Appeal Decision

Appeal Ref: APP/R5510/D/22/3310848

29 Cedars Drive, Uxbridge, Hillingdon UB10 0JU

- The appeal is made under section 78 of the Town and Country Planning Act 1990 against a refusal to grant planning permission.
- The appeal is made by Mr Roman Stets against the decision of the Council of the London Borough of Hillingdon.
- The application Ref 62696/APP/2022/1875, dated 10 June 2022, was refused by notice dated 8 August 2022.
- The development proposed is erection of a part single, part double side/rear extension and front extension.

DRAWING TITLE/NO:
2312_03 - Proposed GF & FF

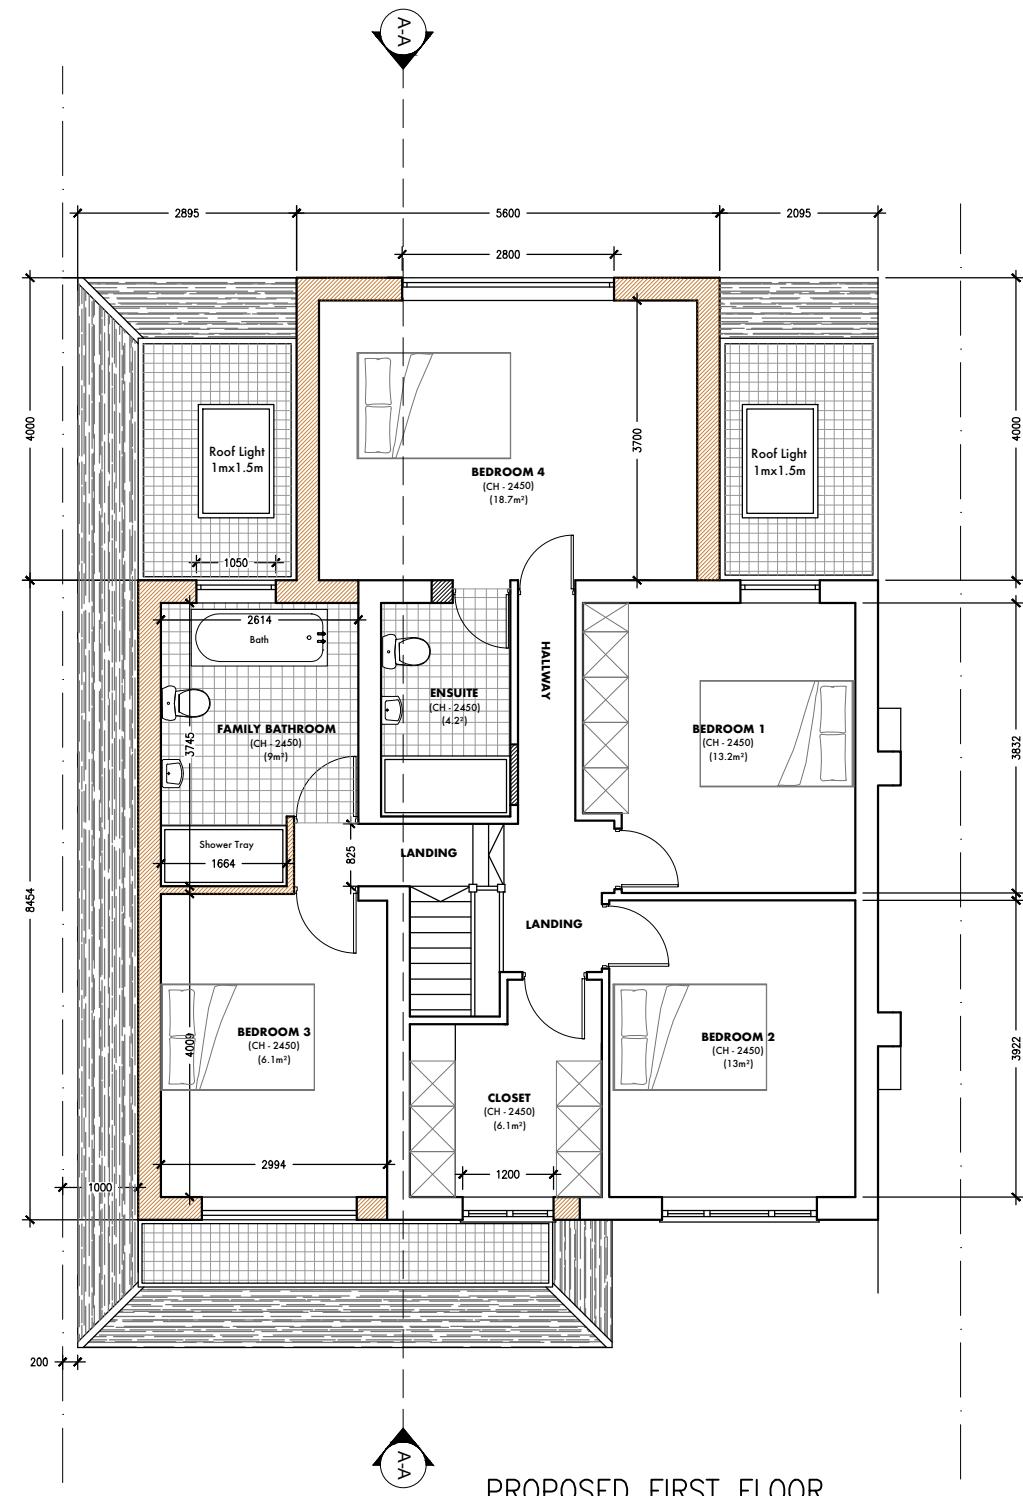
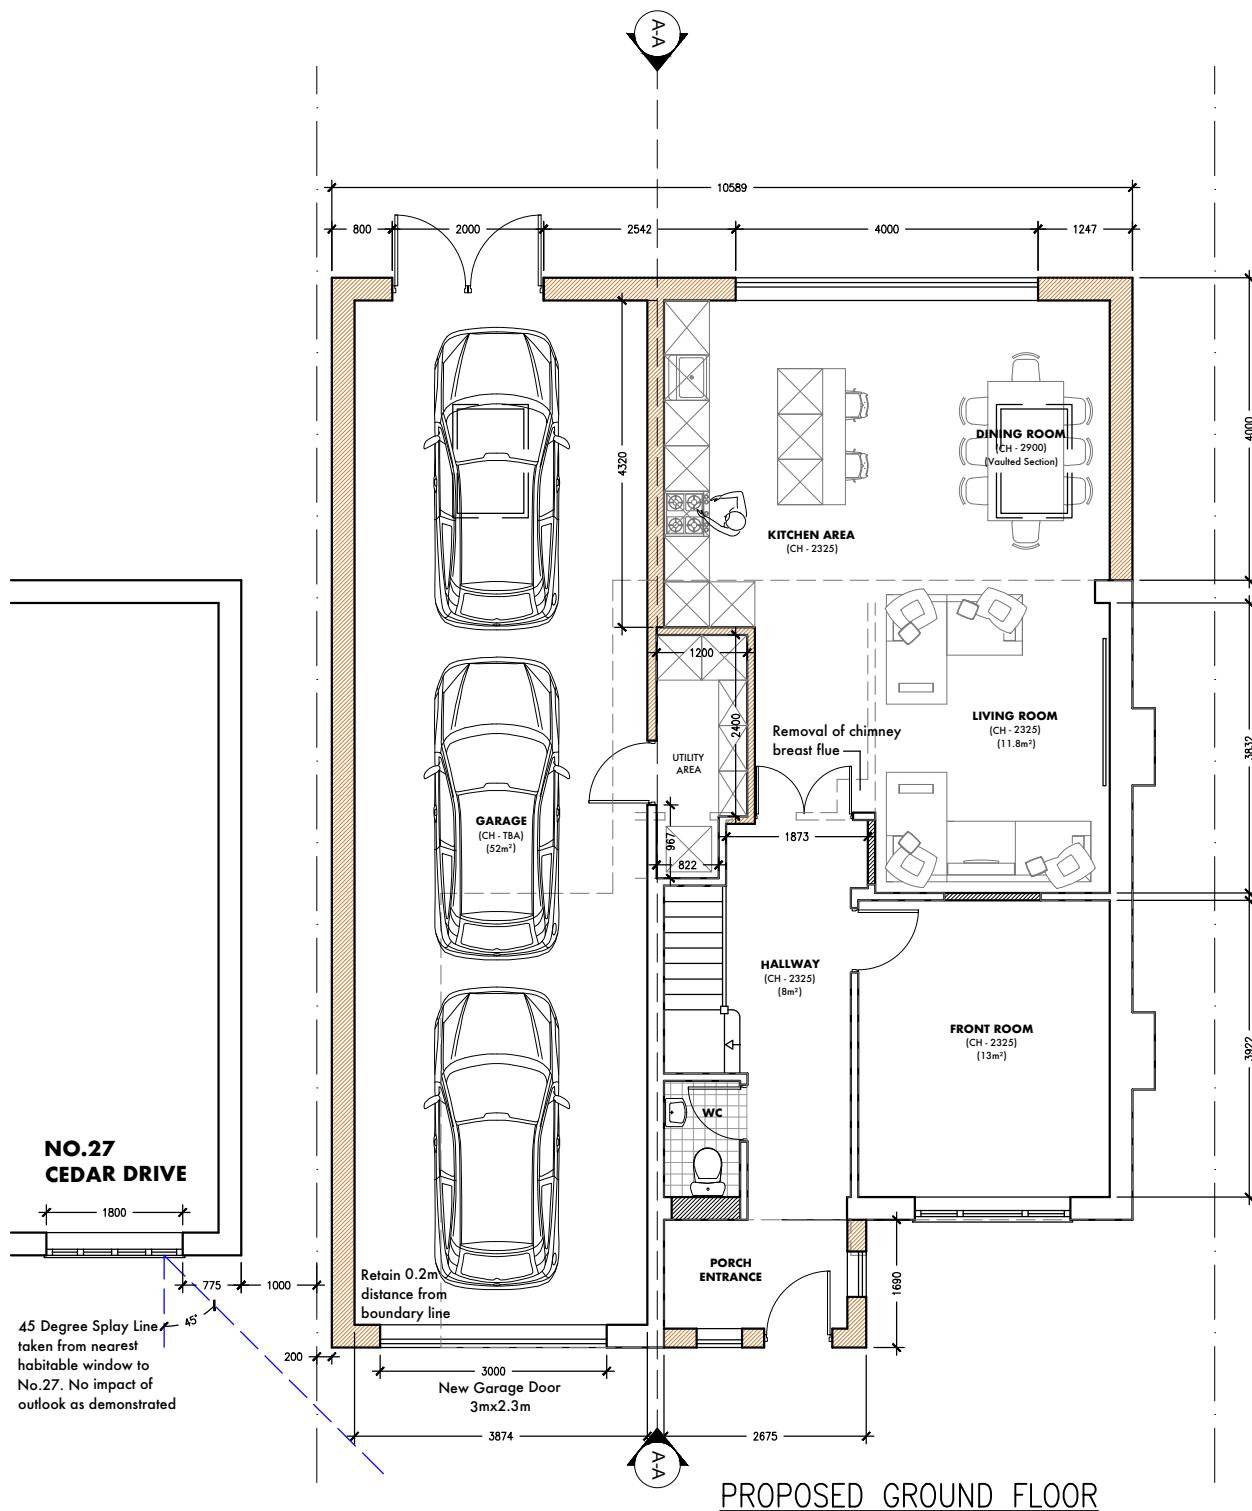
6. The side extension now proposed would be wider than the extension approved under the Previous Permission, and would not be set back from the front of the appeal dwelling at first-floor level. It would be contrary to requirements for side extensions within Policy DMHD 1 of the Local Plan Part 2 Development Management Policies 2020 ('the LPP2') setting out that they should not exceed half the width of the original property, and that two-storey side extensions should be set back a minimum of 1m behind the main front elevation.

7. However, the supporting text to Policy DMHD 1 indicates that the width requirement for side extensions is intended to avoid over-dominance of the original house, and that the set back of extensions from the main front wall is sought to provide definition between the original house and the extension. In this case, the side extension would have a lower roof that would provide for an appreciable point of differentiation from the host building. The set down of its roof would also give the extension a degree of subservience, and it would not in my judgement be an excessively bulky or dominant addition overall.

8. There would be a clear change to the scale and appearance of the appeal dwelling, and I find having regard to the overall width of the extension and the comparable front building line that it could not reasonably be described as subordinate to the host building. Nevertheless, the form and proportions of the resulting dwelling would not stand out against the mixed street scene which already includes buildings of varied form and design. In this context, I find that the development would not be unduly conspicuous or visually intrusive.

9. Moreover, I observed other dwellings nearby with development extending up to or very close to boundaries to the sides of buildings at ground-floor level. While spacing to the side of the ground floor of the development would be limited, its proximity would not be inconsistent with these examples. The extension would also be of lesser width at first-floor level, and I am satisfied that its greater set in from the boundary would be sufficient to provide an adequate visual gap to the neighbour at 27 Cedars Drive in keeping with other development nearby. Given these factors, I find that the development would not be unduly cramped, and the general spaciousness of the area would not be harmfully eroded.

DRAWING TITLE/NO:
2312_07 - Existing & Proposed
Elevation Drawings

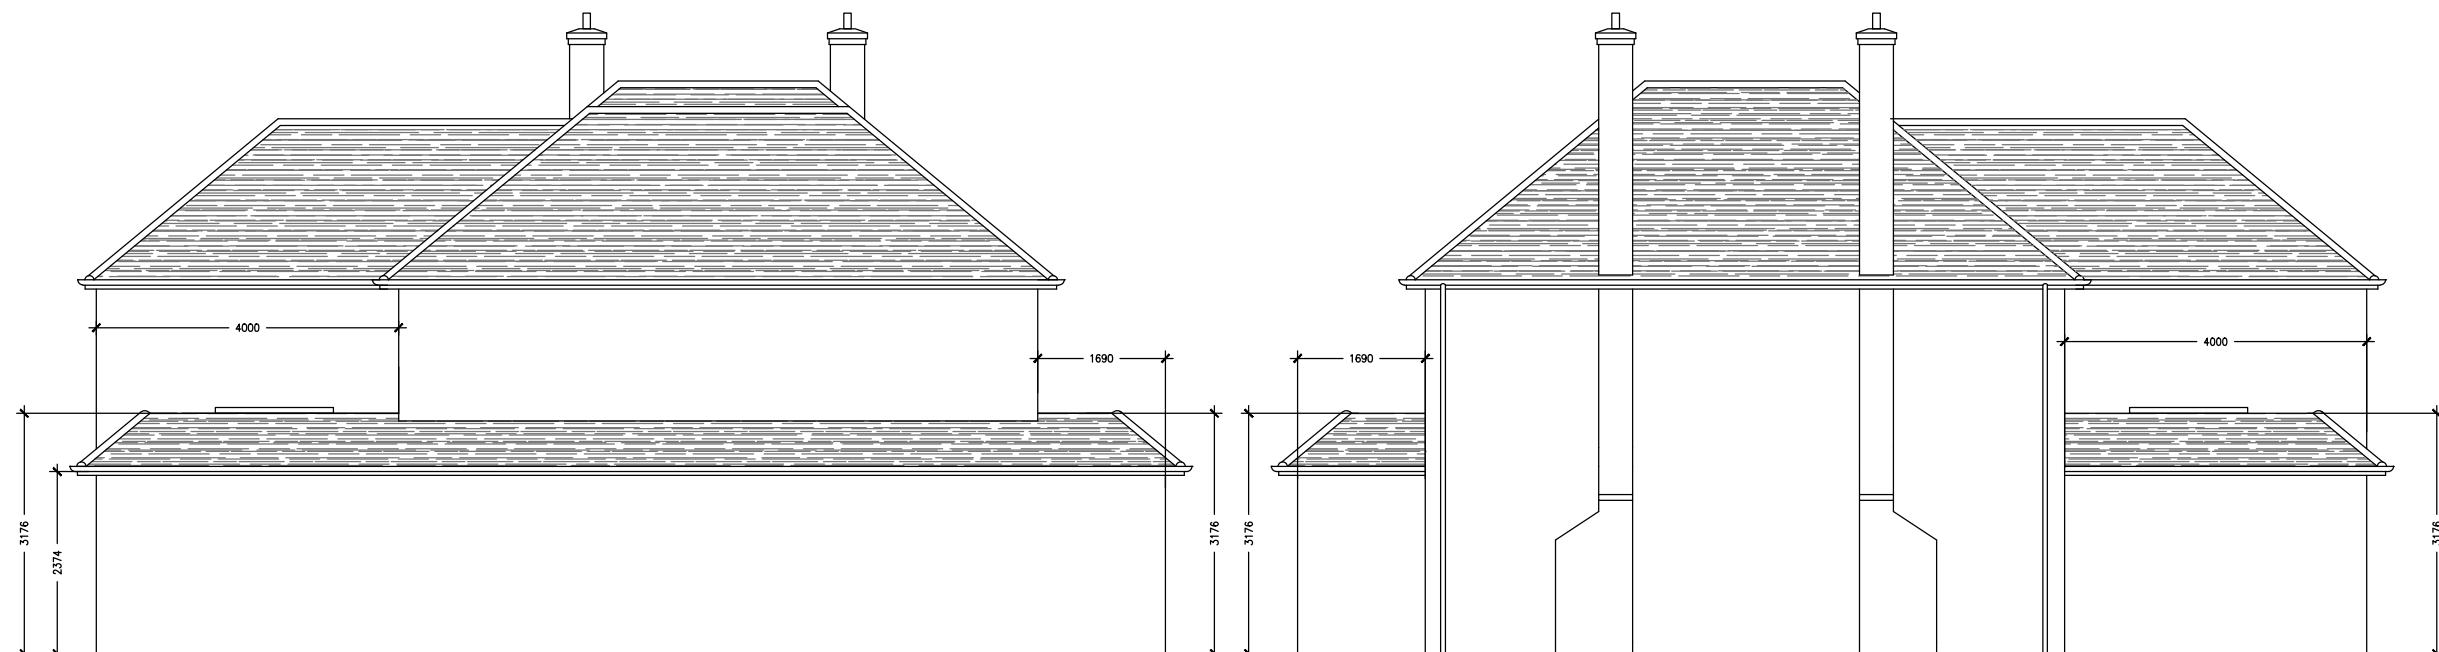
11. The extensions to the rear of the dwelling would be set in from the boundary with 31 Cedars Drive, and there would be a greater set in to the first-floor level. No 31 is also set in from the boundary, and I consider that there would be sufficient separation to ensure that the extension would not cause unacceptable loss of light or outlook for occupiers of this neighbour. In addition, any effects would be comparable to those of the Previous Permission which includes rear extensions of similar depth, height and proximity to No 31. The development would project closer to the boundary with No 27 than the Previous Permission, but this neighbour has a two-storey rear extension, and I am satisfied given the relationship that there would not be unacceptable harm to living conditions for the occupiers of this dwelling.
